# SEA LINK

EN020026

## Comments on Submissions received by Deadline 5

Suffolk County Council

Document Title: PROVISIONAL MITIGATION AREAS

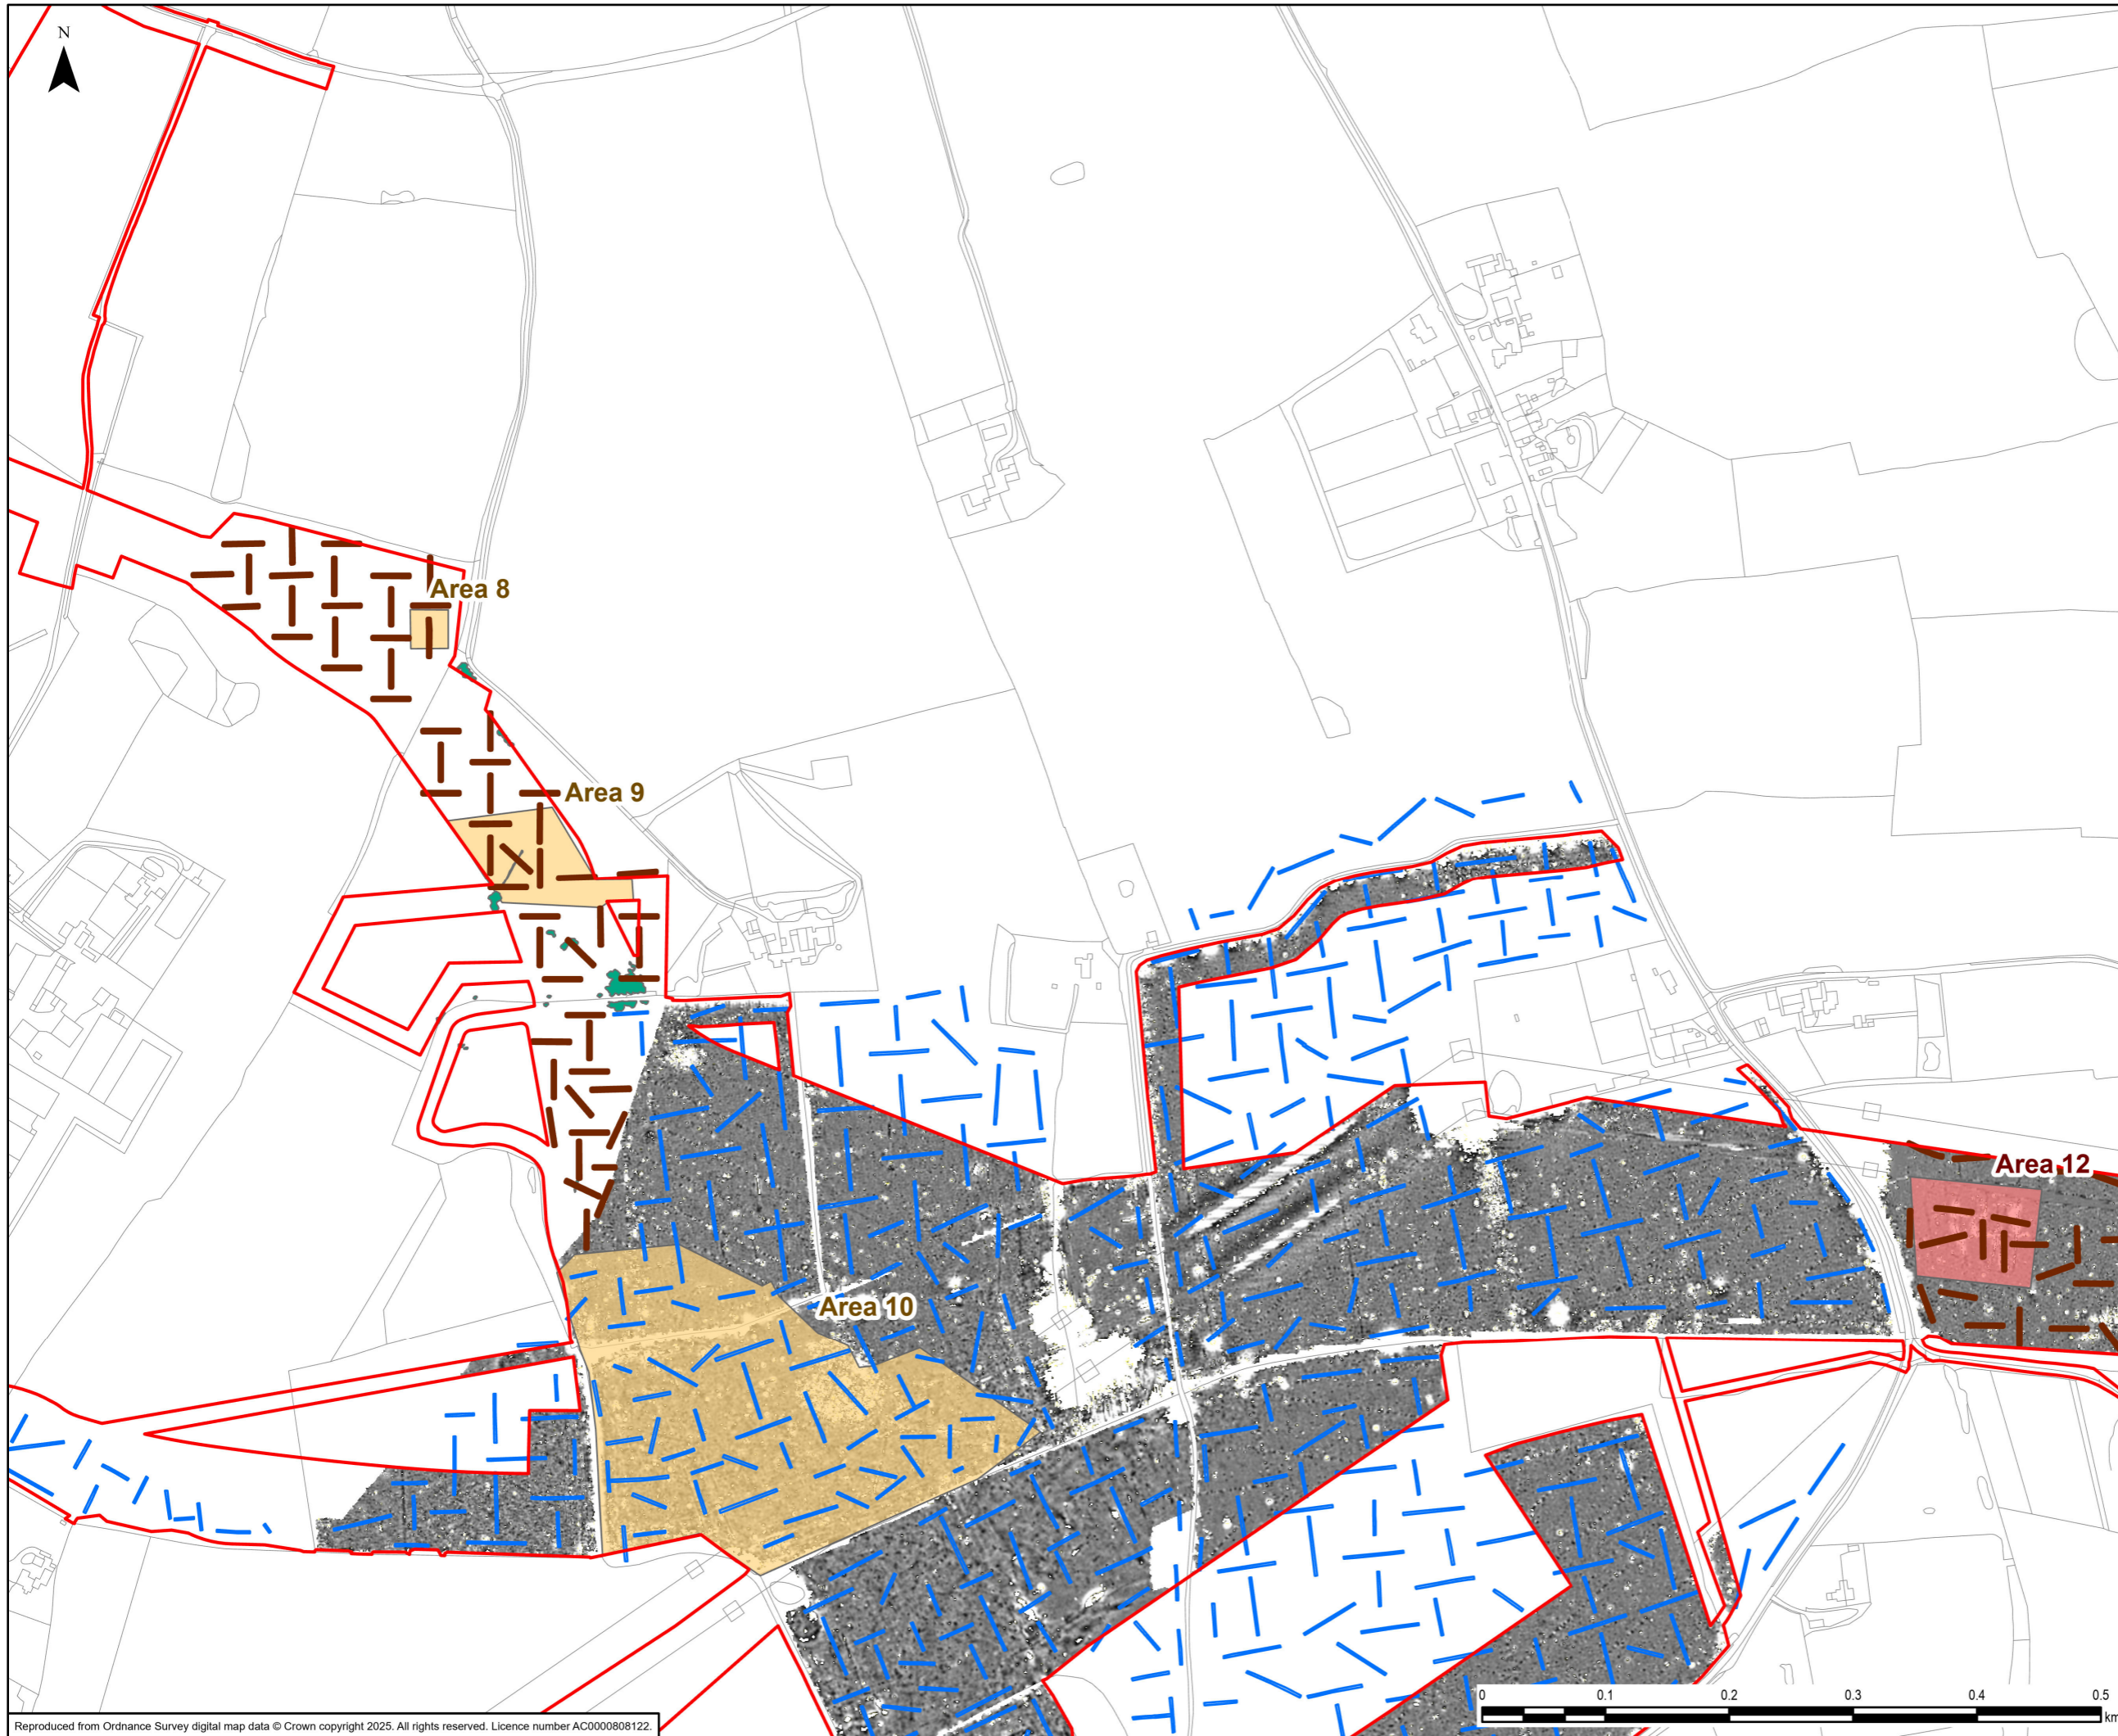
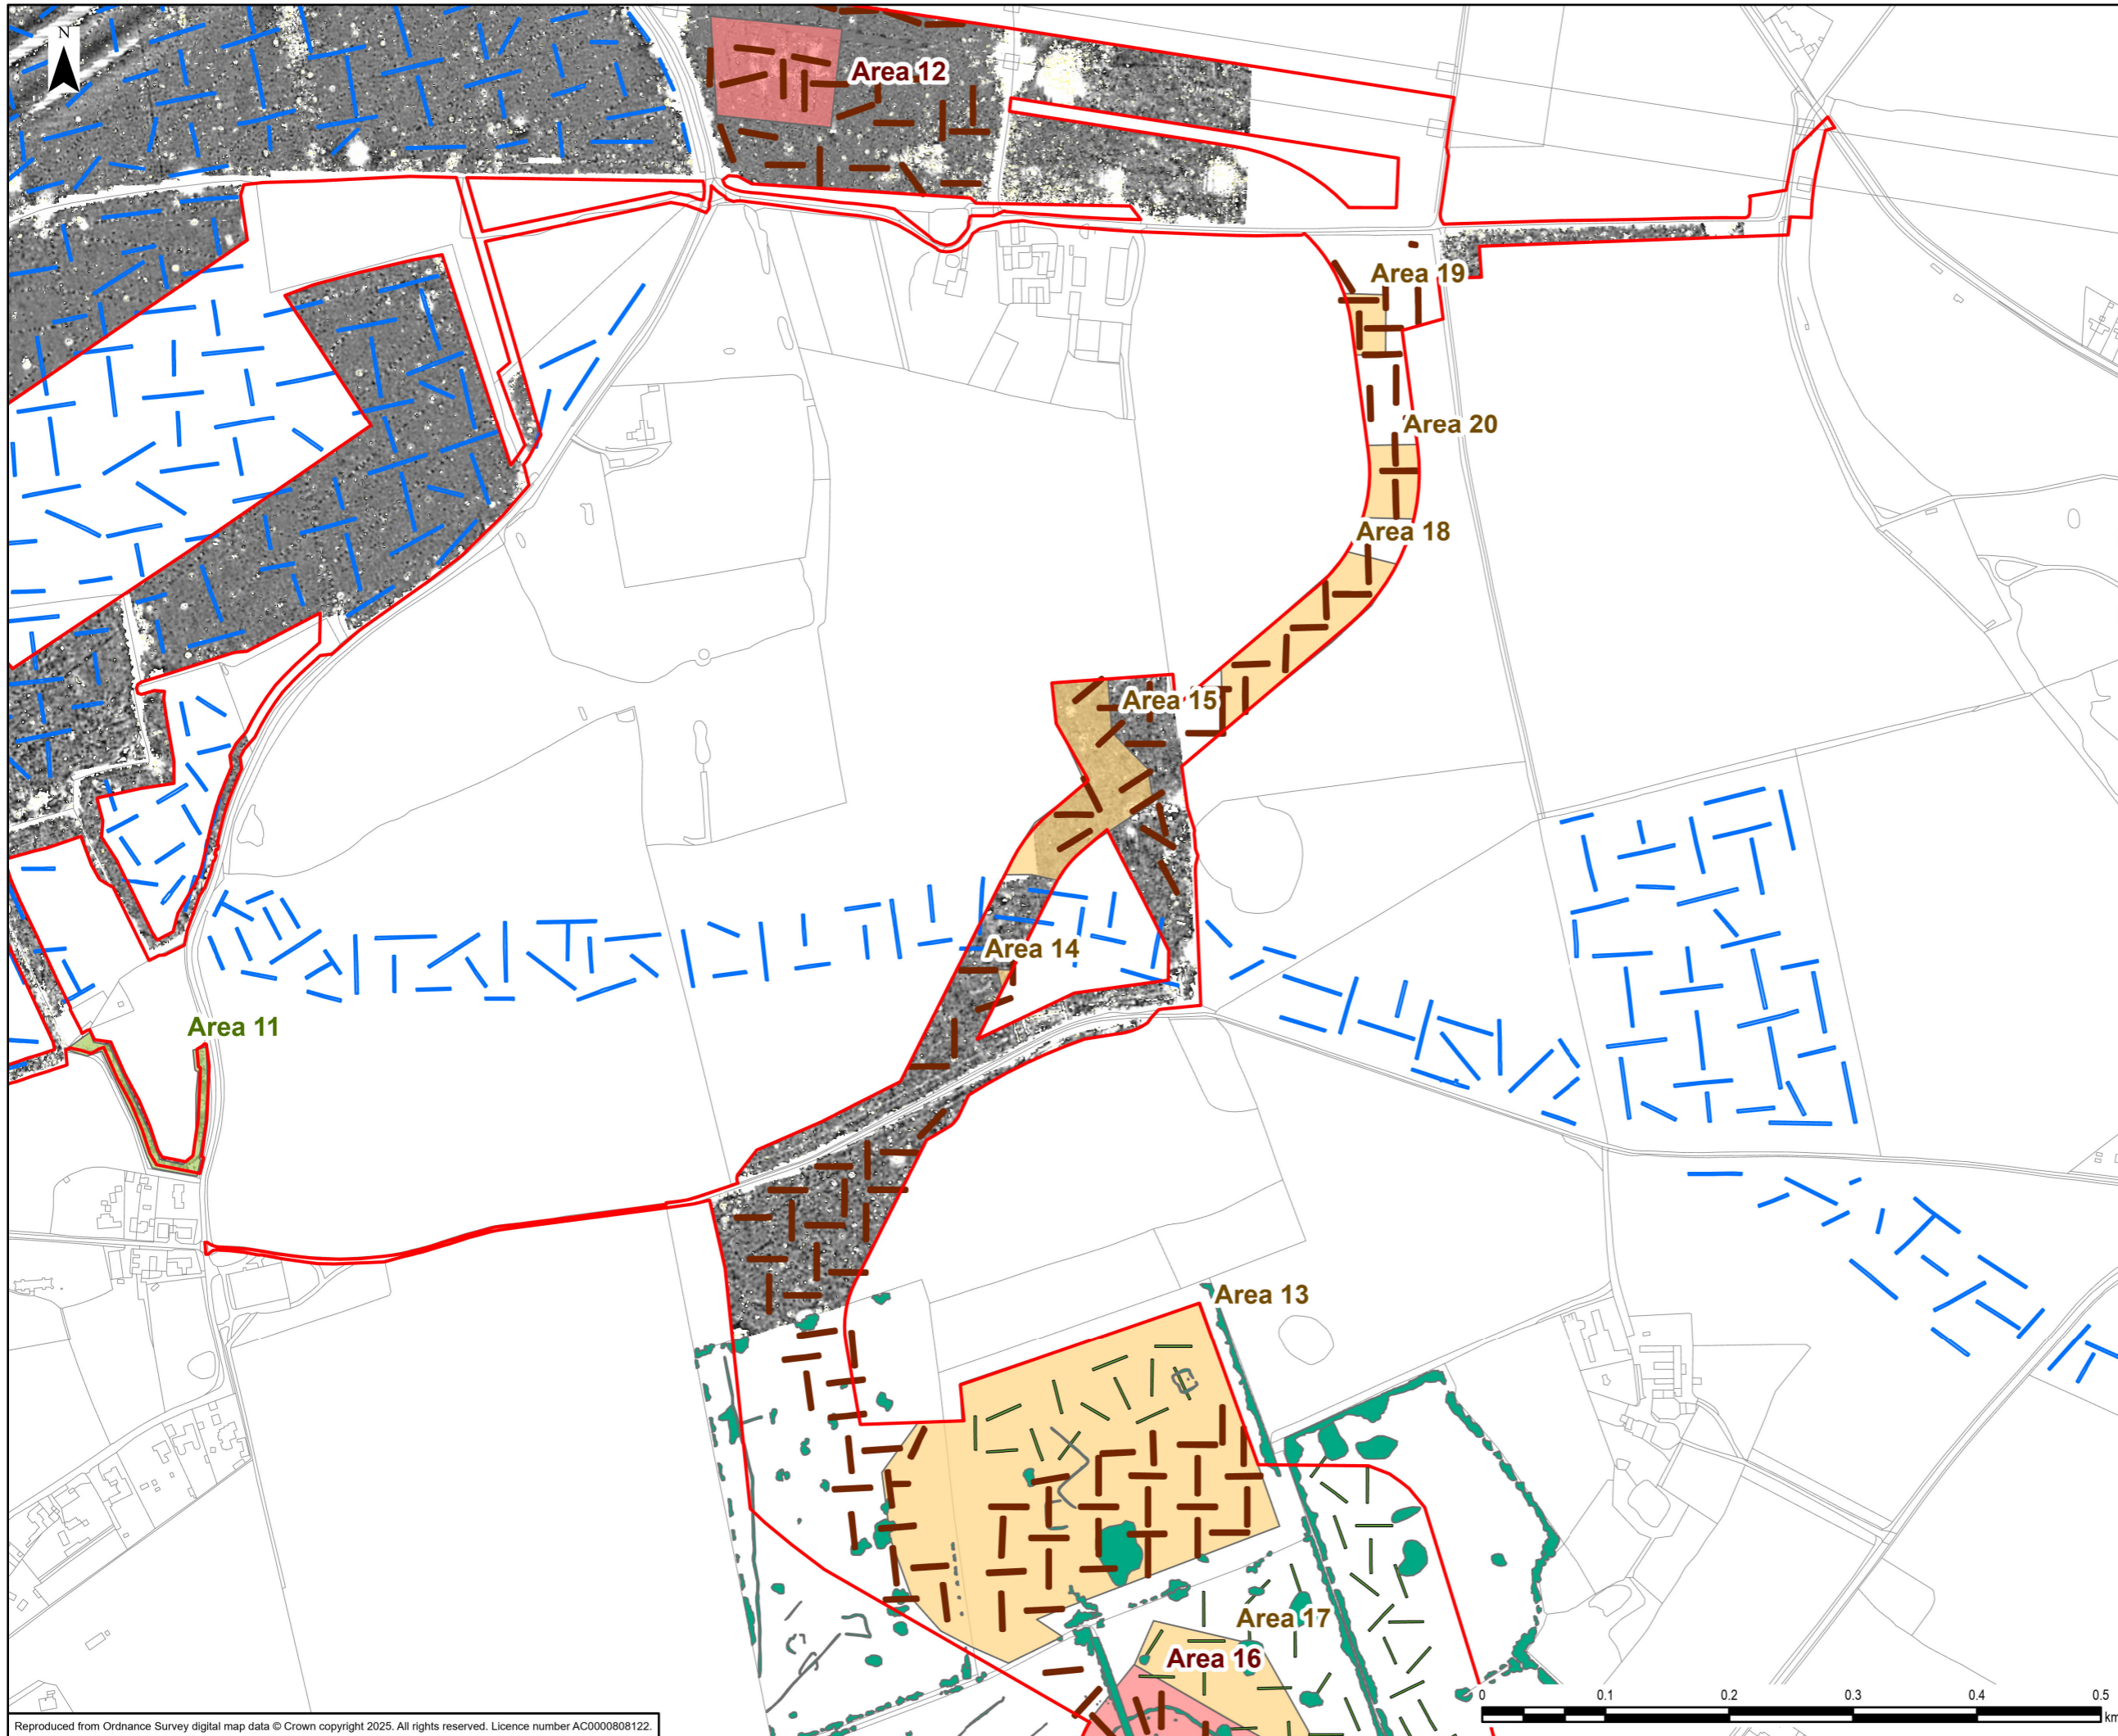
4)		Mitigation areas/scope	<p>1.3.4 SCCAS have provided detailed comments regarding mitigation areas and the scope of the ongoing evaluation and mitigation work which is required for the project to the Applicant’s archaeological consultant. As such, Appendix A is not currently approved as not all mitigation areas are yet agreed and as an up to date and clearer plan showing the evaluation status for different areas of the scheme is needed.</p> <p>However, SCCAS would advise that as the final scope of evaluation and mitigation work will be agreed within the site specific WSIs, that plans showing provisional mitigation areas should be omitted from the OWSI as it is a working document and likely to change.</p> <p>SCCAS would advise that what is required in the OWSI is an up to date plan showing the status of evaluation works for the entire onshore area of scheme in Suffolk and clearly identifying which land parcels have had evaluation works</p>

Ref. No	Topic	Summary of submission	SCC Response
			completed and those where evaluation/assessment is still pending, based upon the latest order limits and works plans.
